RFI

RFI #: 200
 Date: 10/22/2012
 Job: EB-02 Keller Springs Lofts
 Phone: 877-777-5115

Subject: B2 Part 4 unit Columns and patio dimensions

SHEET NUMBER
3.1C
BLDG PLAN 'C'

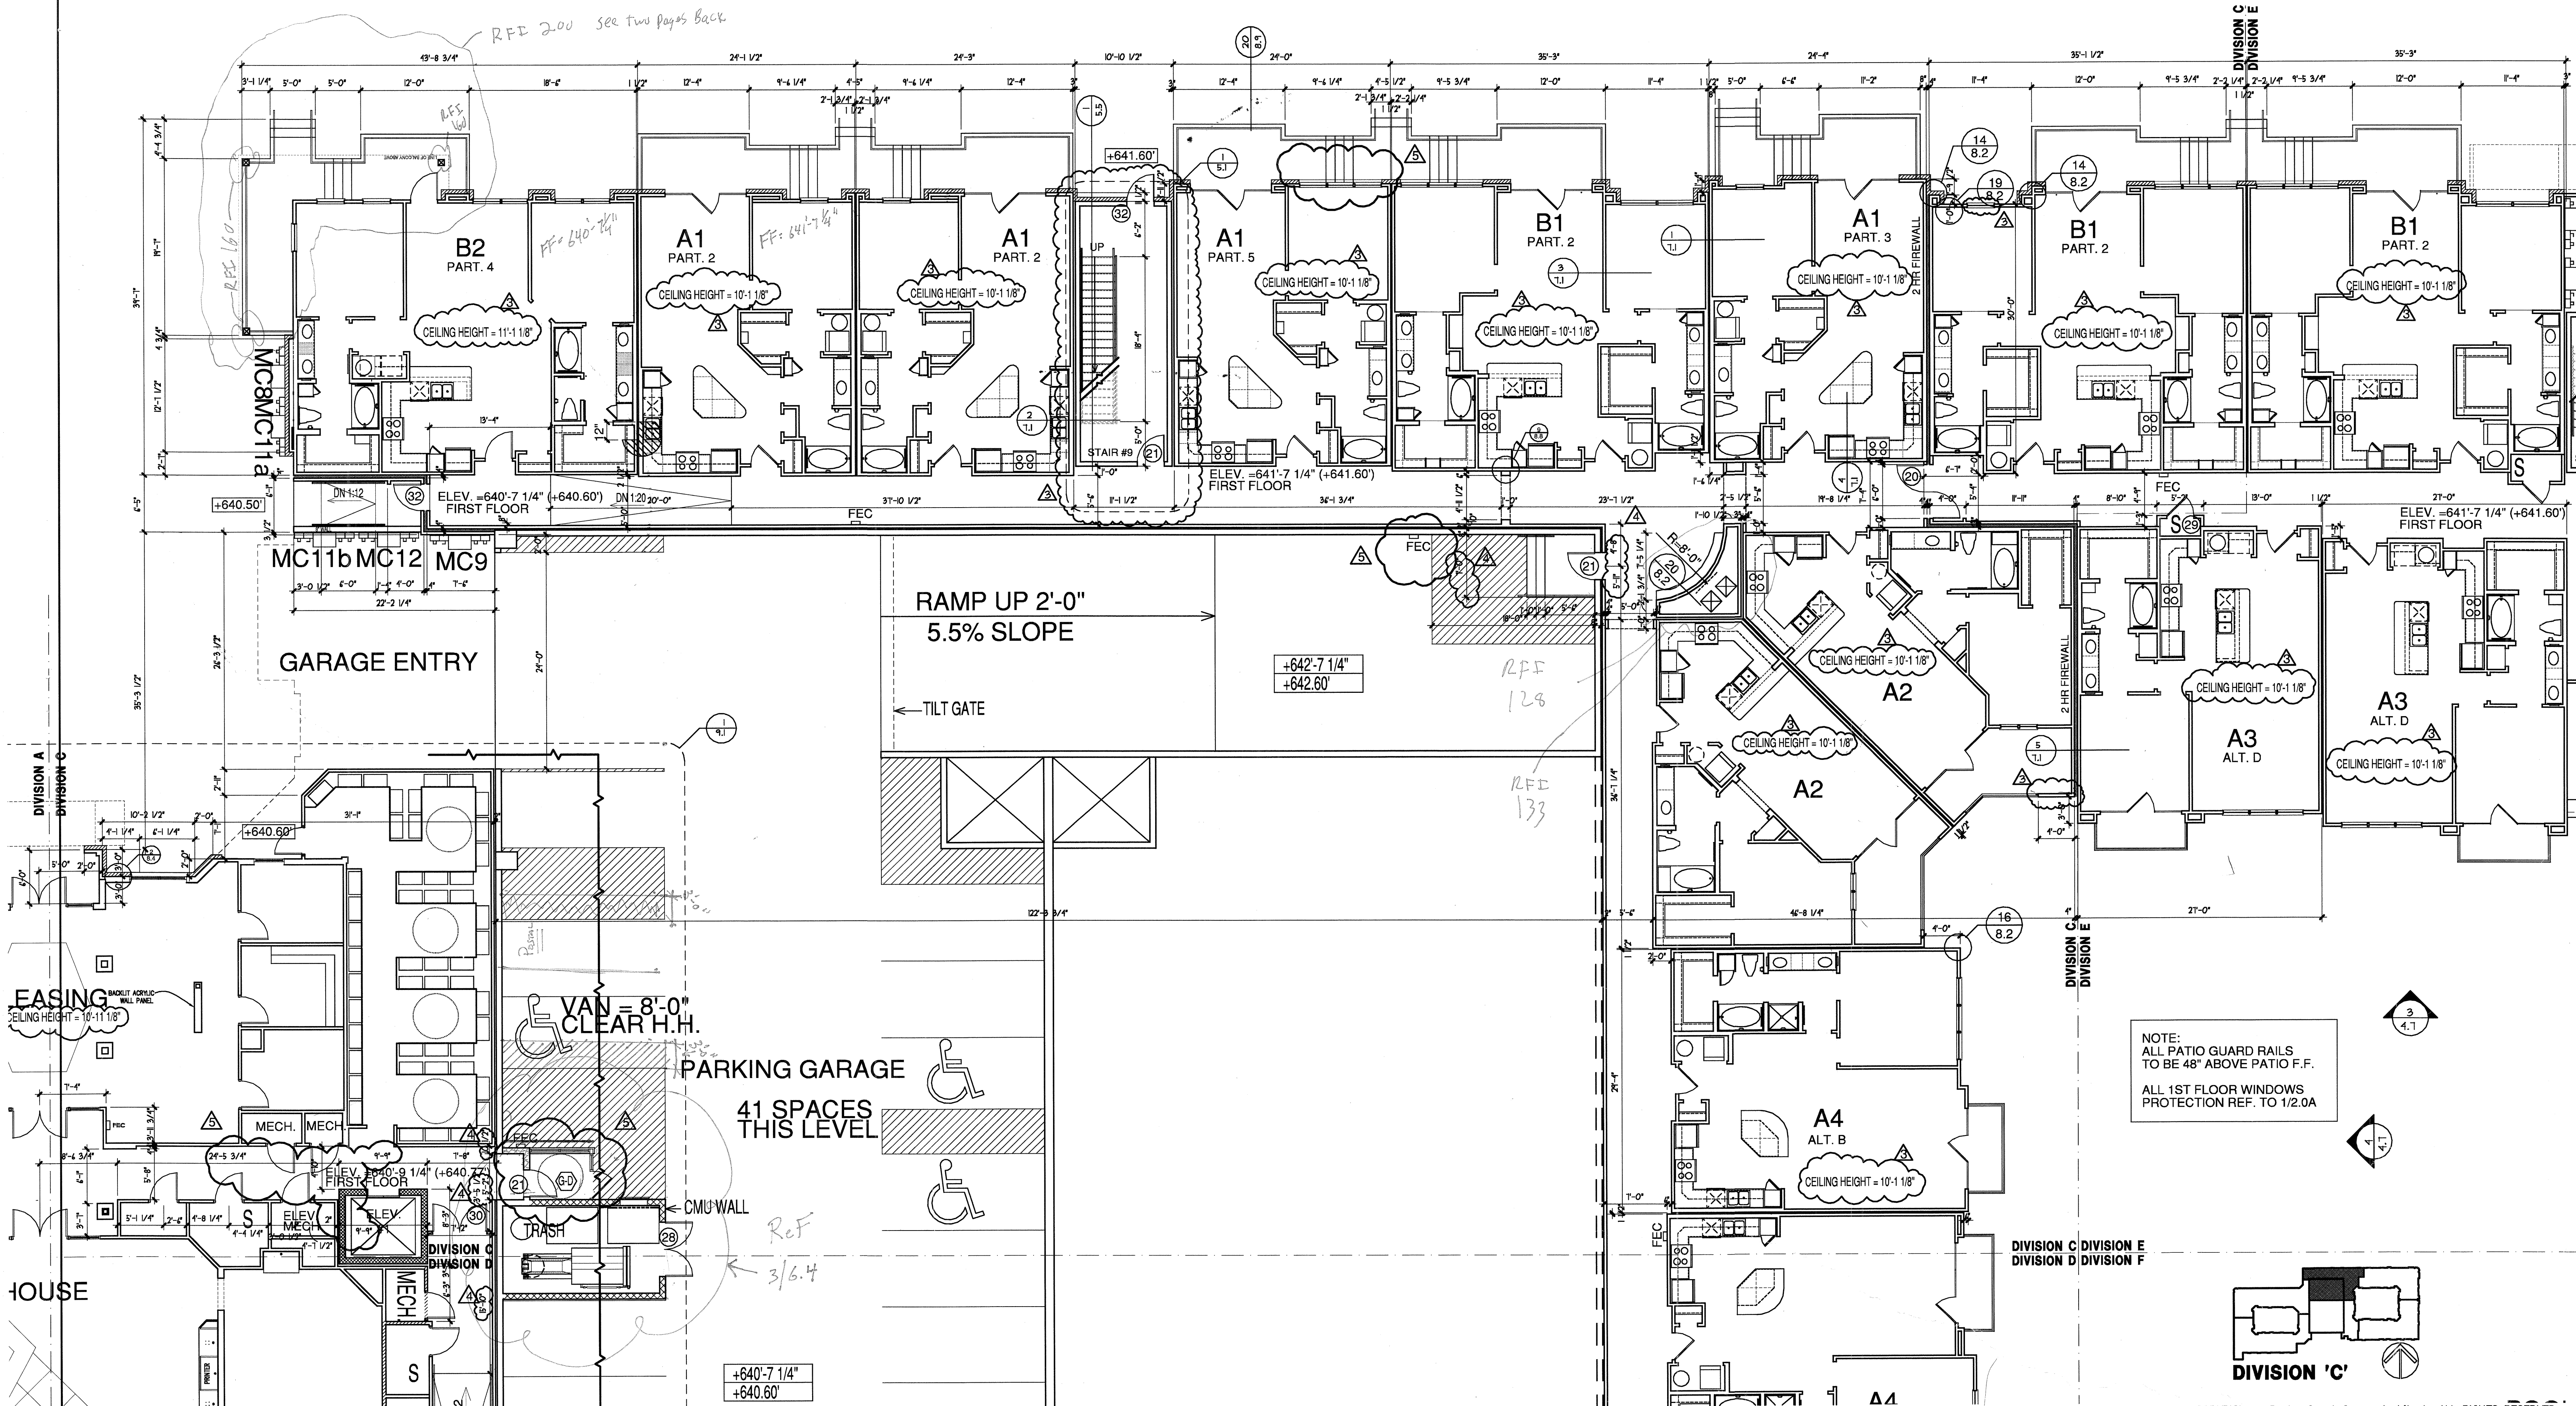
Request: The attached RFI from Red River Framing is in reference to the B2 Part 4 unit columns and patio dimensions on 2/ 2.7A vs. the B2 Part 1 unit balconies above shown on 1/ 2.7A. The B3 Partial 1 units show the supporting walls 6" past the support columns from the B2 Part 4 units. Please review and advise. Date Required: 10/24/2012

Response: PPO takes no exception to the cantilevered truss solution proposed below.
 Please ask BGO to confirm that the solution is acceptable Architecturally.

BGO suggests cantilevering the trusses for these B2 units in question as shown in the next pages of this PDF only if the Trusses are signed and sealed by an engineer in the state of Texas.
